Plan One
1501 Dayton Court NE
Renton, WA 98056
(206) 612-8511

RE: Permit Number-Intake 2
2101-001-Intake 2

INTAKE COMMENTS RESPONSE

**5**

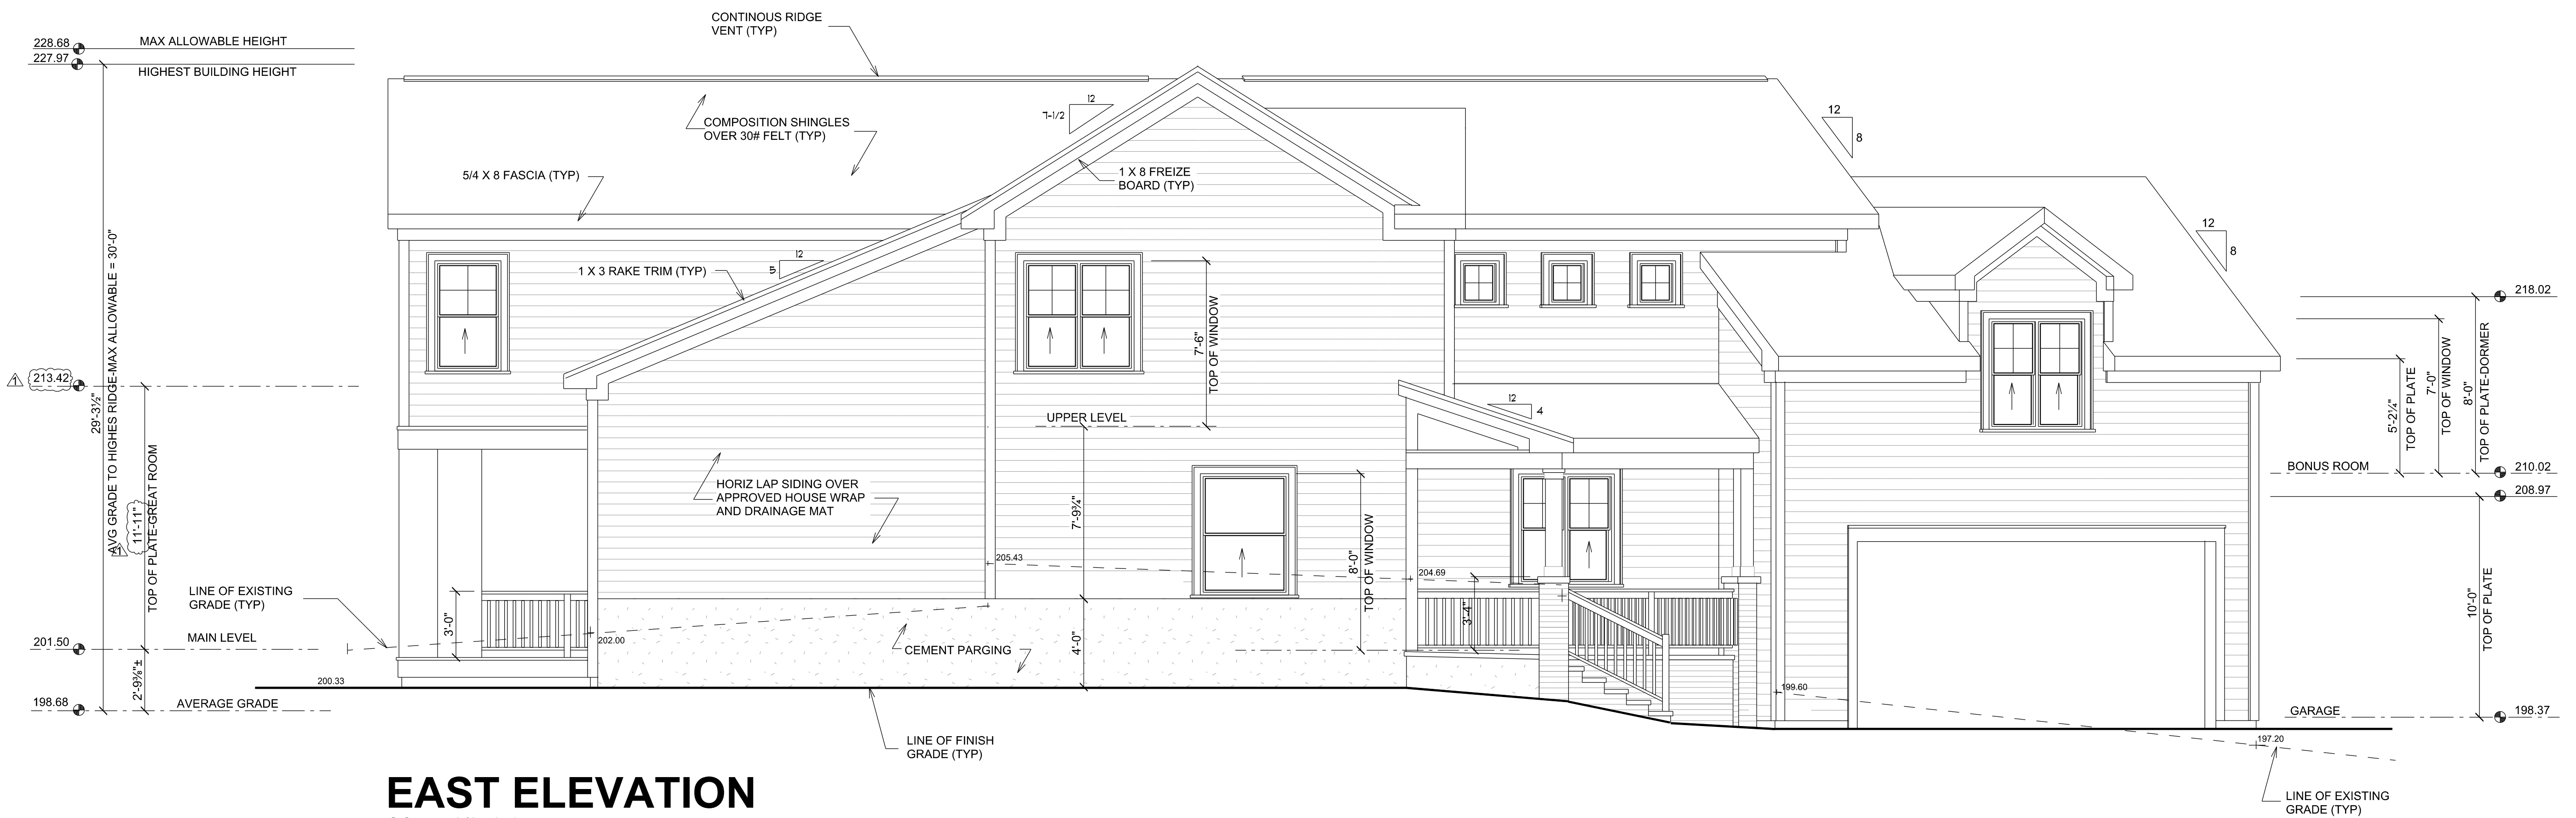
Allowable Building Height has been indicated on all elevations, Sheets 5 & 6

SHEET	<b>S-6</b>
OF	1
JOB #

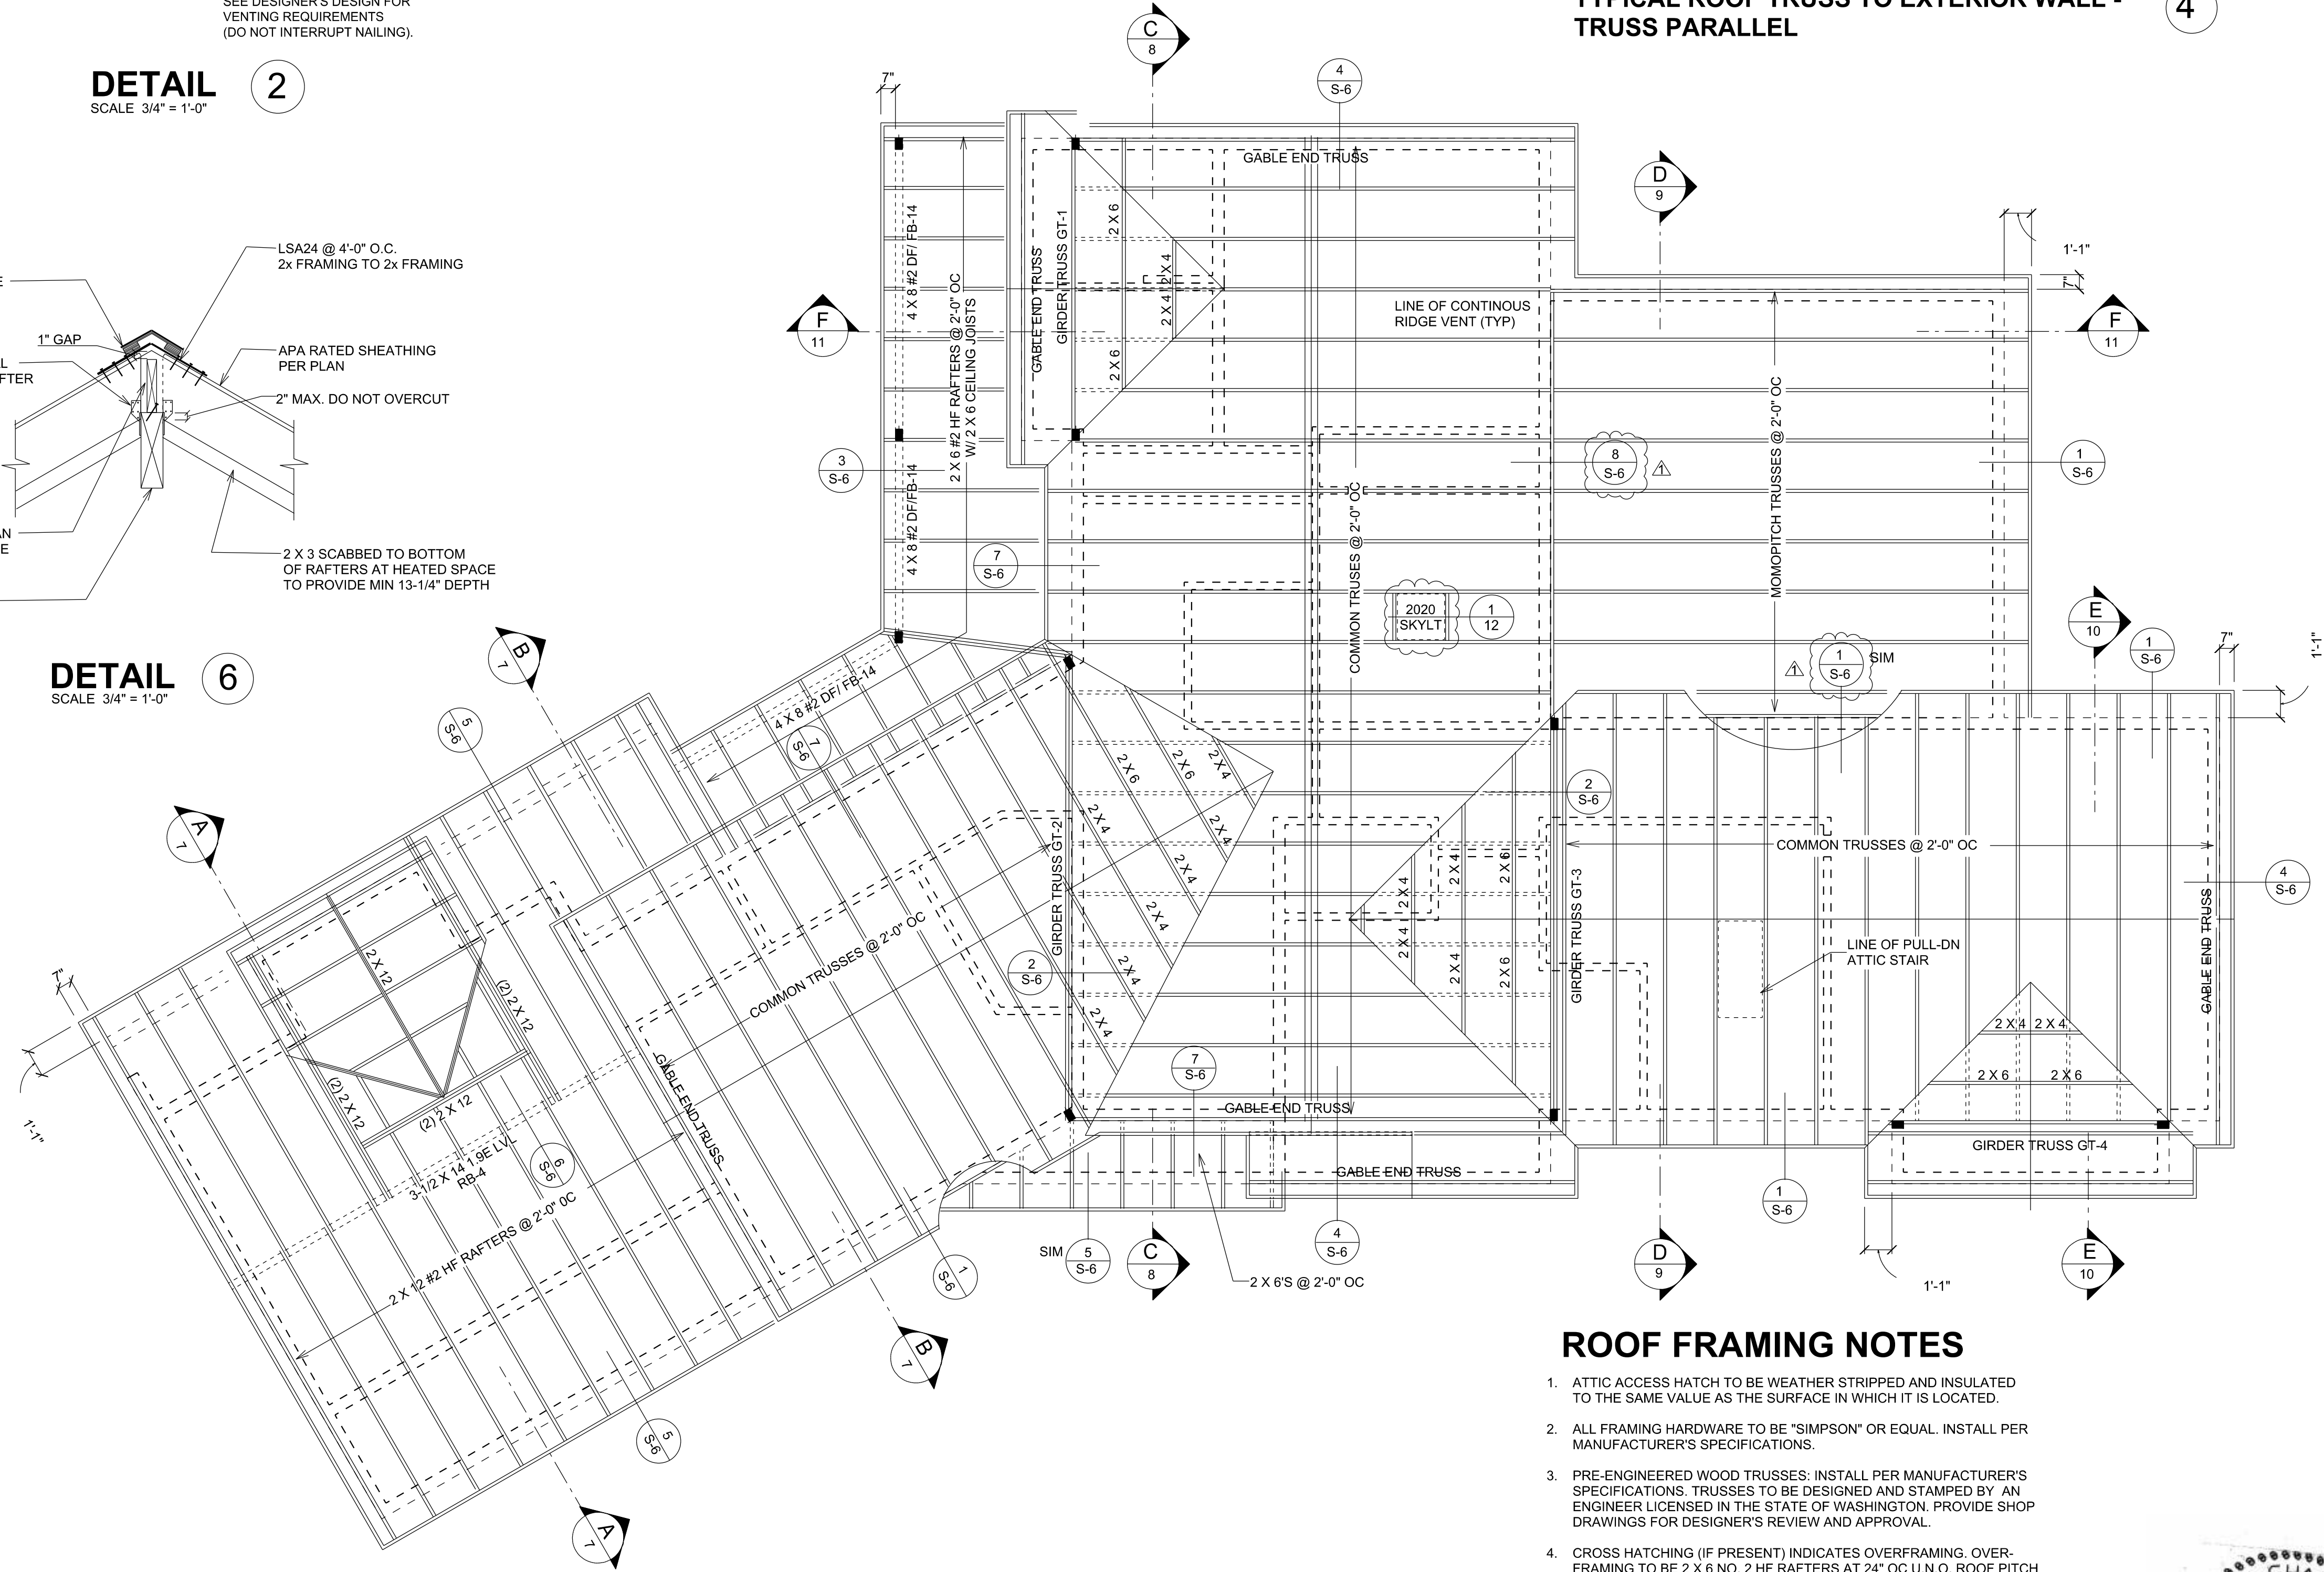
Gravity framing plans were provided, Sheets S-4, S-5 & S-6

SHEET  
**S-7**  
OF  
-  
JOB #

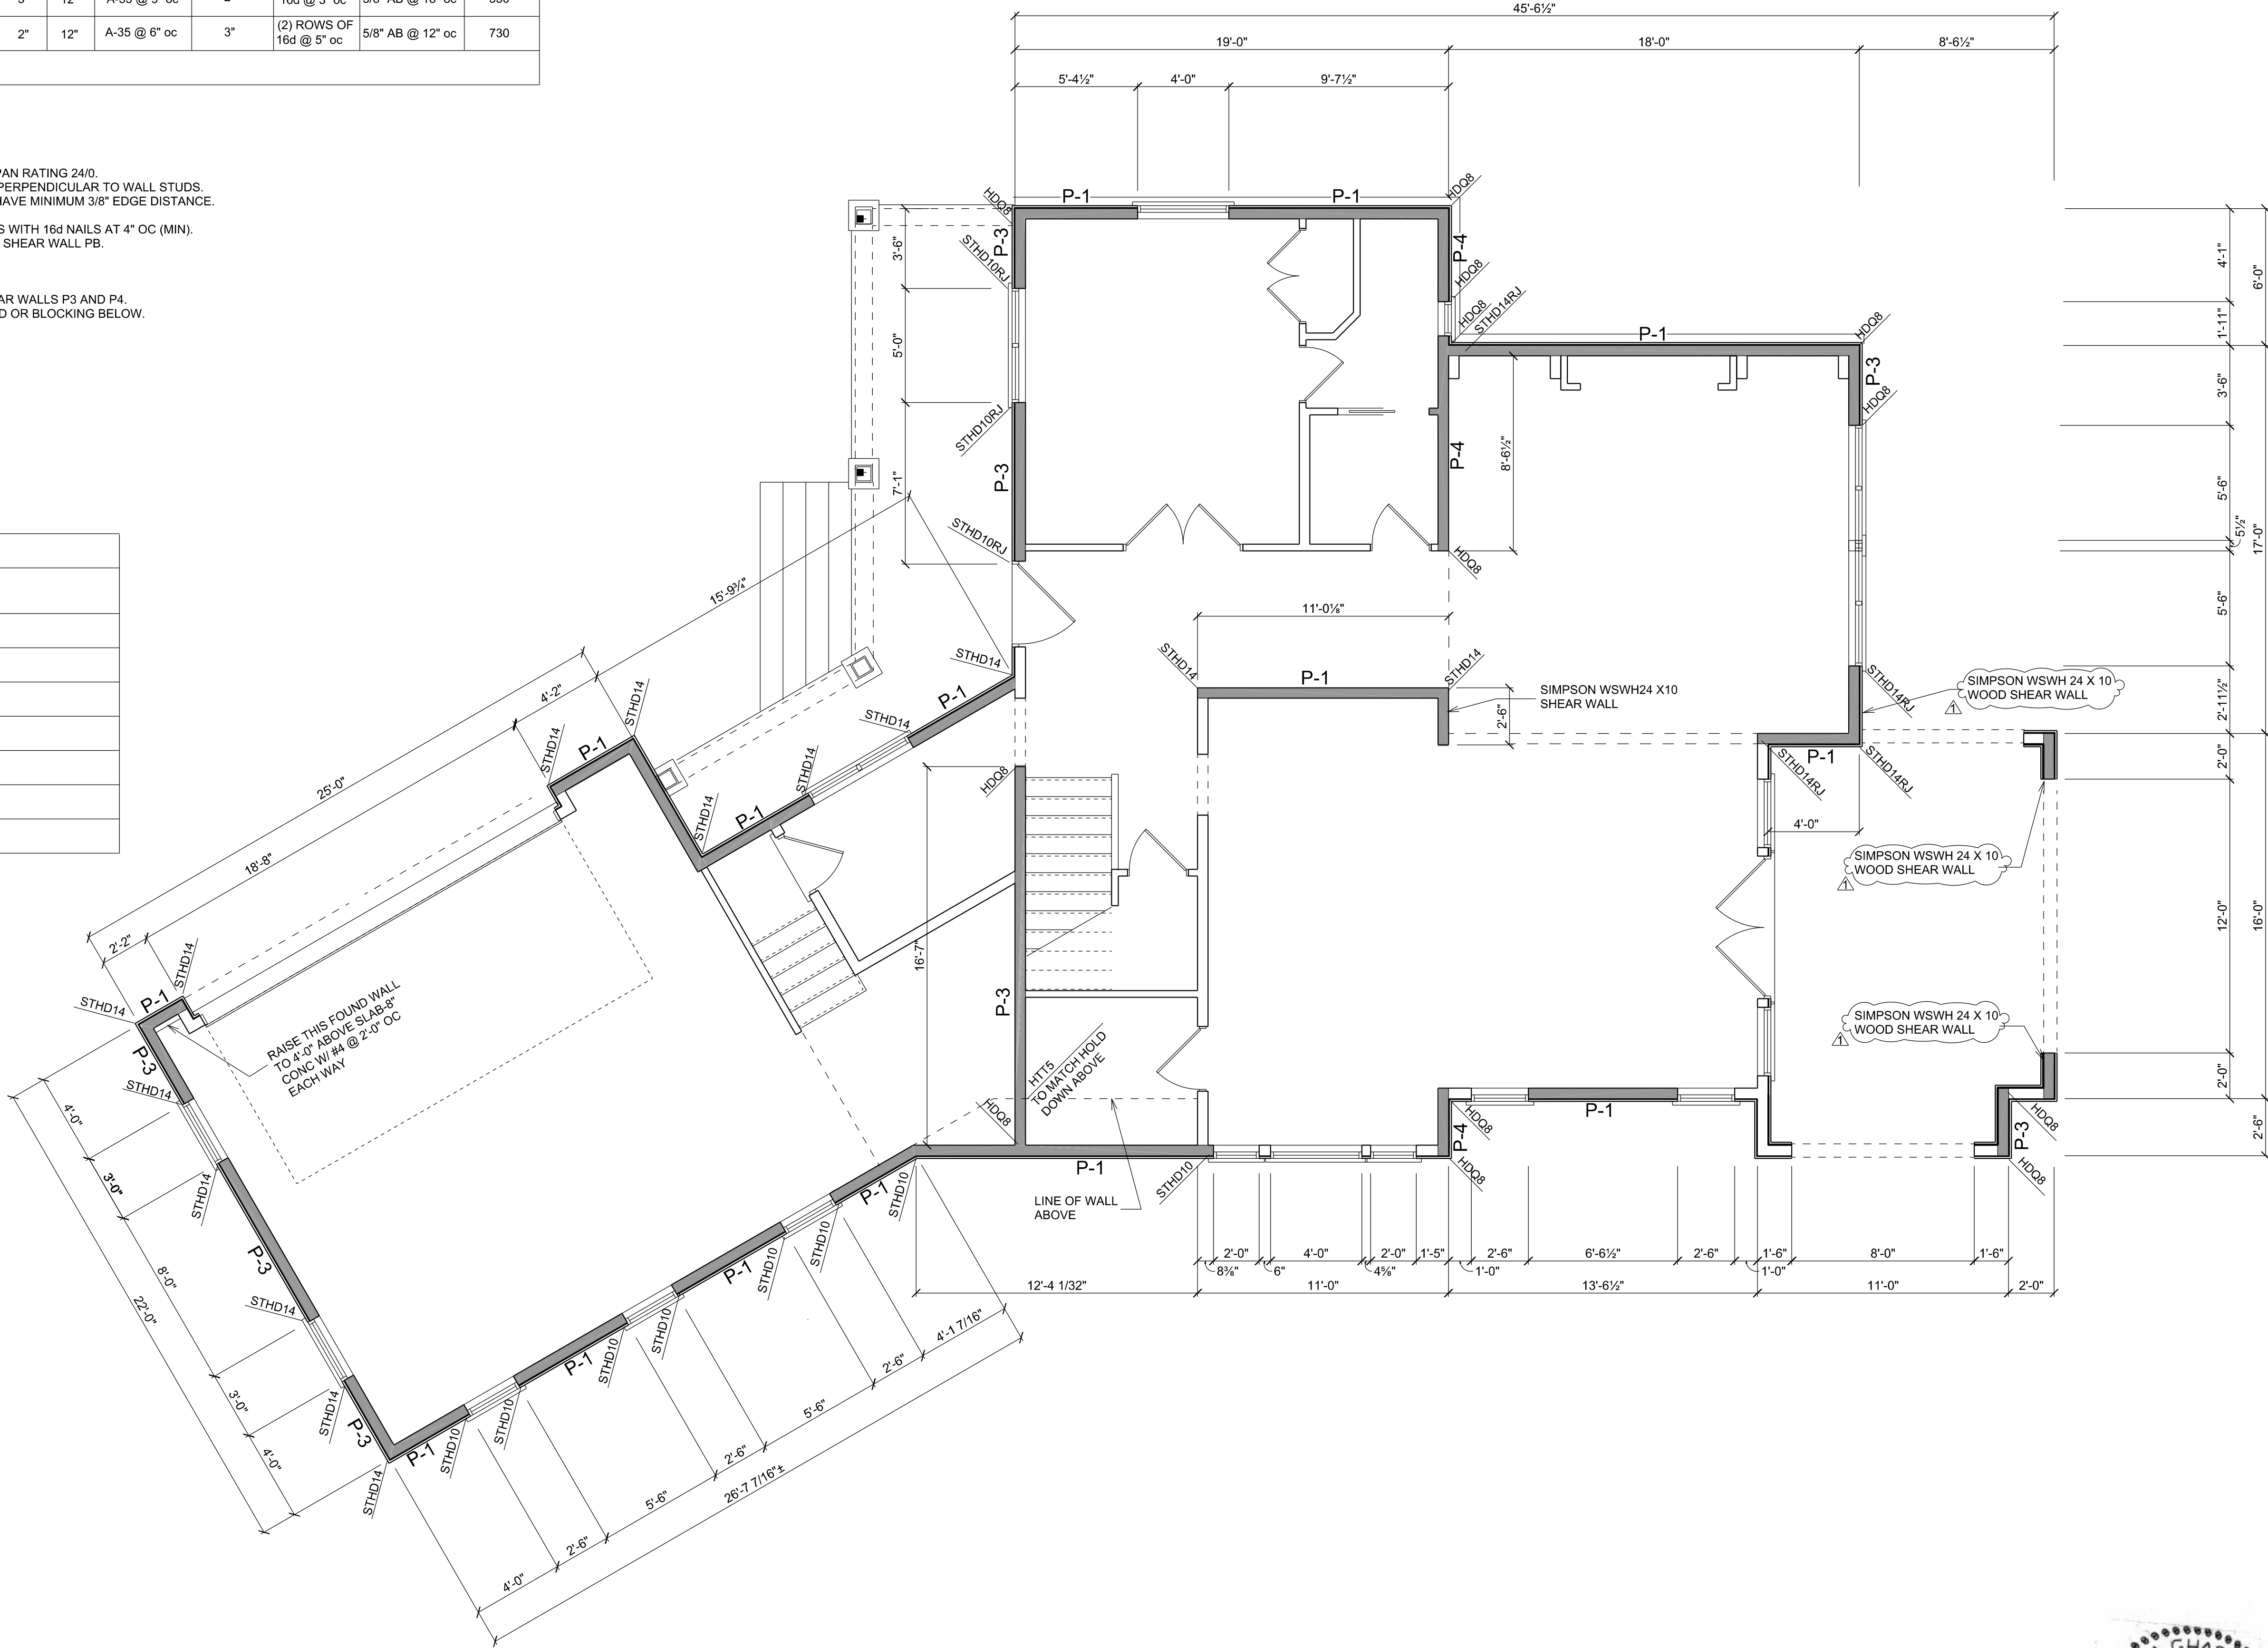
Structural Calculations & Methodology: Shear Wall Plans were provided with the original submittal, Sheets S-7 & S-8.
